From: Sue Howell
Sent: 24 April 2017 14:52
To: Planning.Responses
Cc: David Easton
Subject: RE: Planning Consultation on: A/44/17/OUT

Comments from Greenspace

A/44/17/OUT

Site Address: Land west of Brook Lane and South of A259 Angmering BN16
3JL

MASTER PLAN

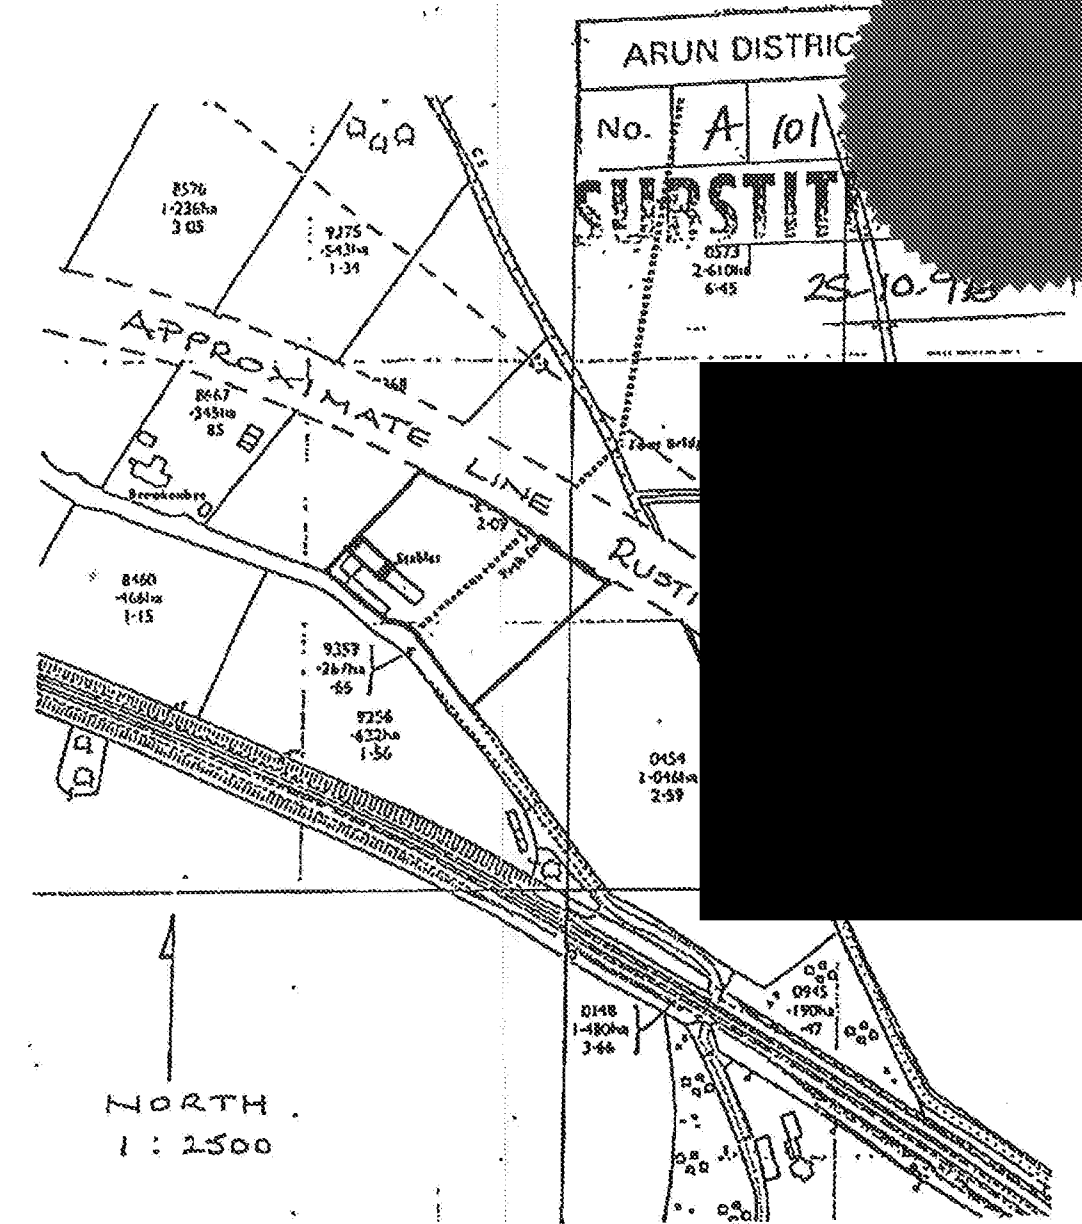
The provision of landscaping for the development must be conditioned with any permission. Some indicative landscaping particularly trees detailed have been illustrated with the masterplan. Forming part of any decision consideration or as a minimum reserved matters a full landscape scheme should be submitted for approval, detailing species choice, position, densities and size at time of planting. This should be plotted in plan and list form and in relation to the trees and vegetation to be retained in the locale, so that a clear picture of the proposals can be seen. These details are required to assure the adjacent land setting is maintained, the setting is uncompromised and the proposals are appropriate to its setting also its proximity in relation to neighbouring properties and South Downs National Park to the North. Landscaping would be required as a buffer and considered acoustic buffer because of the sites location between railway line and roadway. The existing hedgerows on the site would need to be retained and enhanced and any gaps filled using native hedge species the purpose of these to create wildlife corridors across the site The landscape scheme should maximise the biodiversity of the site with the inclusion of native species and the retention of a variety of habitats. The long term management of the developing landscape would need to be considered.
